Planning Application Reference No.: 3/2024/0020

Address of Development: Alston Dairy
Alston Lane
Longridge
PR3 3BL

From: [REDACTED]
Sent: 08 March 2024 13:27
To: Planning
Subject: Planning Application No 3/2024/0020 Commercial retail development Alston

ROOF PLAN

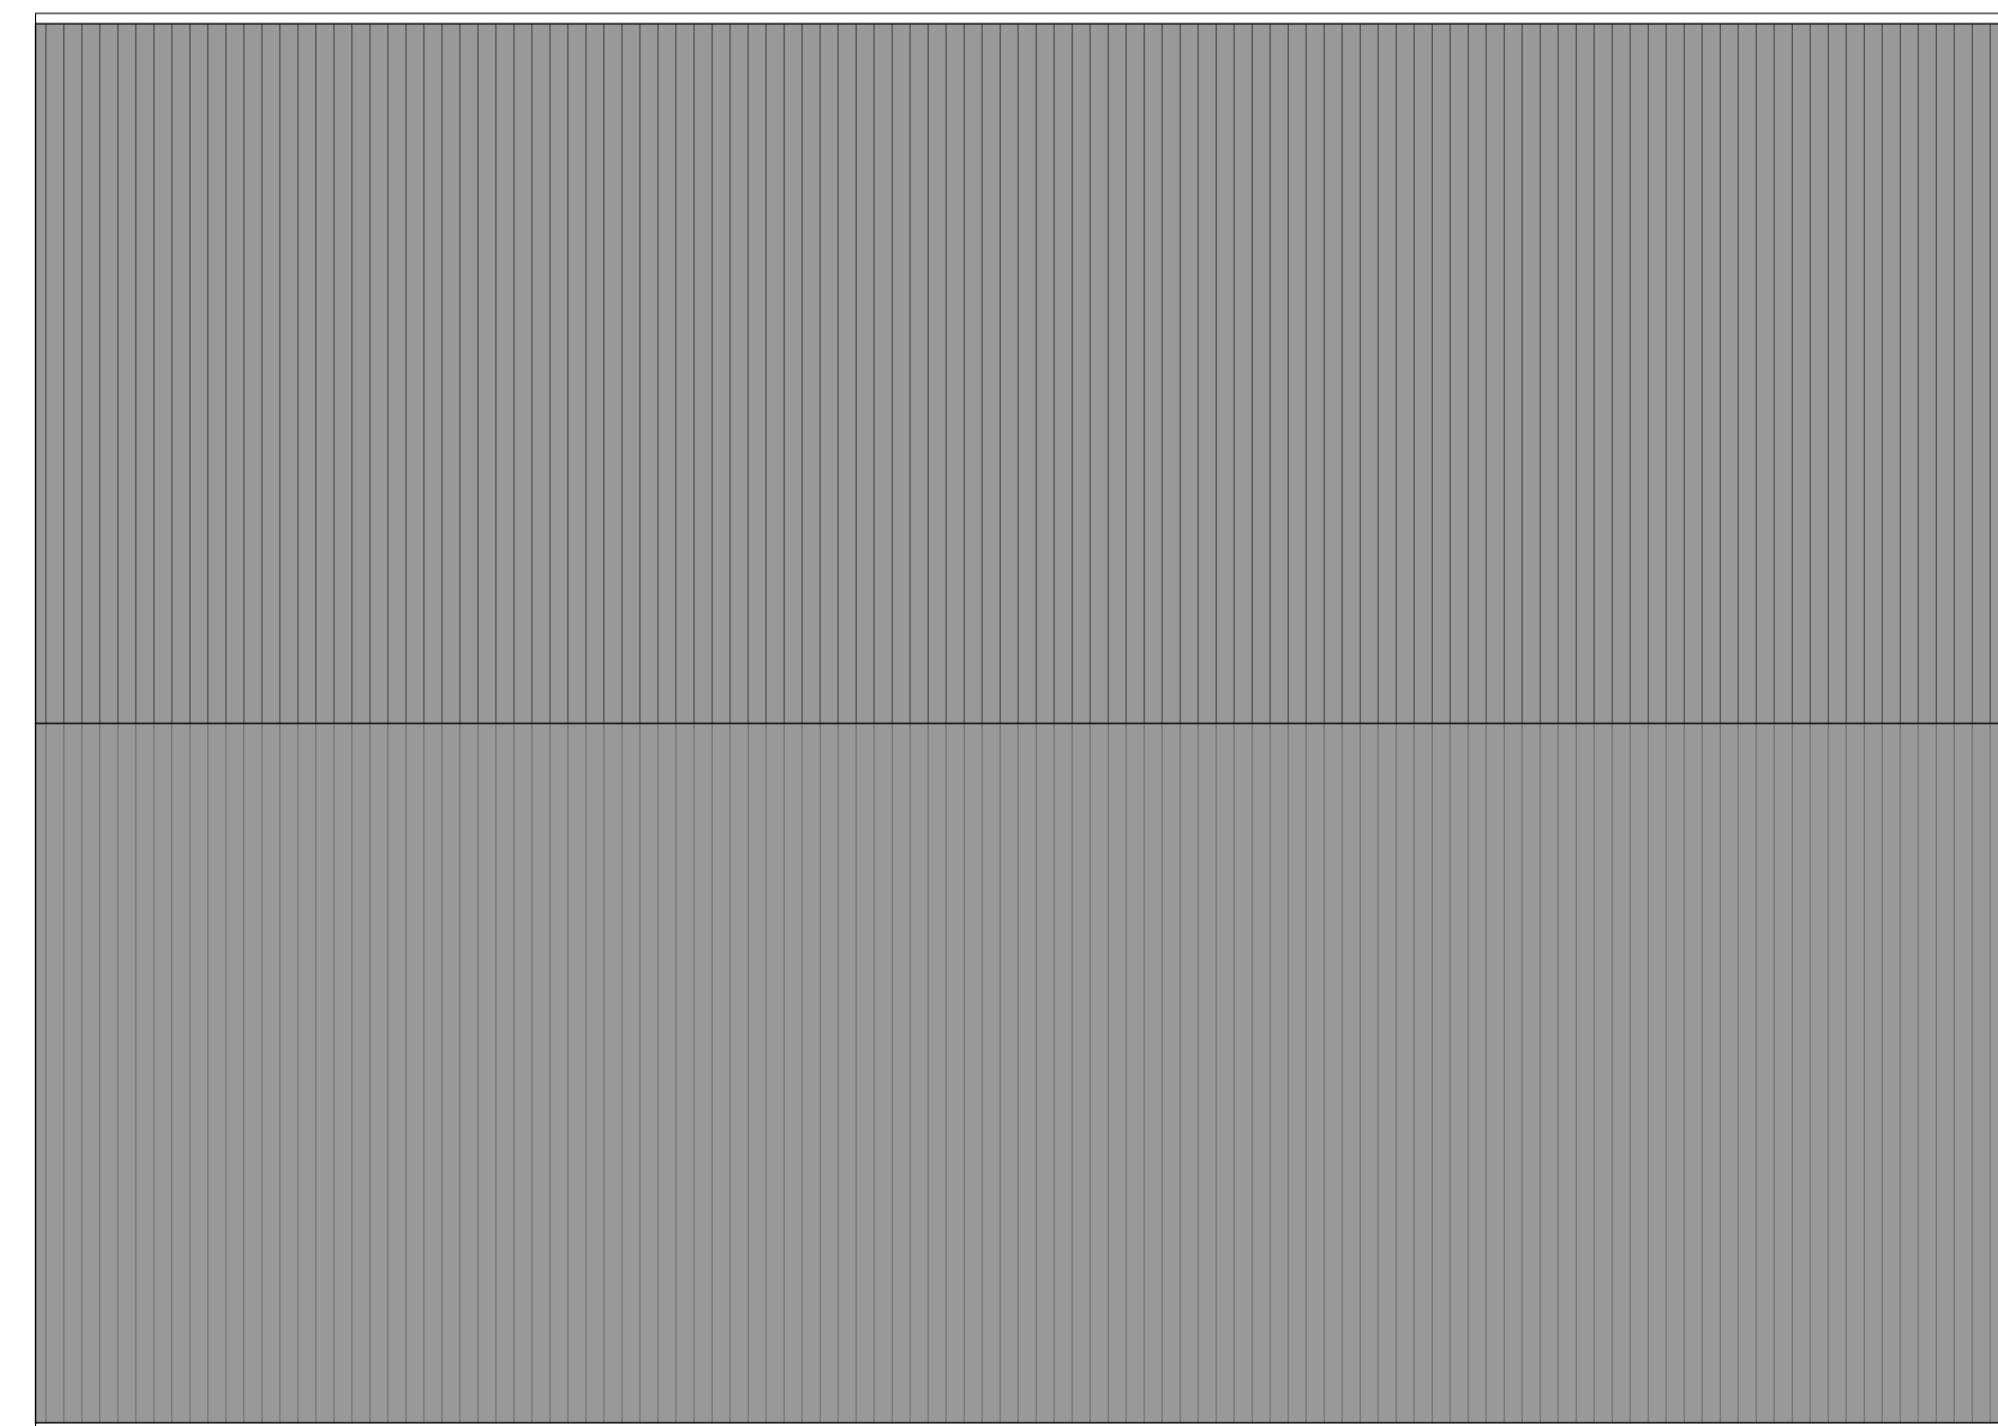
The proposed store, although described in the transport statement as a 'small storage building', is in fact a substantial 465m² structure that would look completely out of place in open countryside, and I can see no valid reason to justify positioning it in that location. If the store is ancillary to the farm shop or dairy, then surely it should be close to the other buildings with access through the existing, more suitable dairy entrance. If not ancillary, it could be sited elsewhere, for example on an existing industrial site or a more suitable brownfield site; somewhere where it would blend in and not be an horrendous blot on the landscape.

I therefore request that you do not support this proposal in its current form, principally because the proposed store is too big, located in open countryside, out of keeping with the area and would cause increased traffic flow through a totally unsuitable junction.

- The storage facility is directly in front of a neighbouring property which seems unfair given the adjacent land available to the west of the proposed storage facility. Whilst we understand that 'rights to a view' do not exist, the storage facility does in our opinion alter the character of the area. The opportunity to locate the storage facility within the existing footprint of the dairy and planned shop seems to make much more sense. The current separated development away from the dairy does nothing to protect green space as it creates a development discontinuity. How much more open green space are we willing to lose?
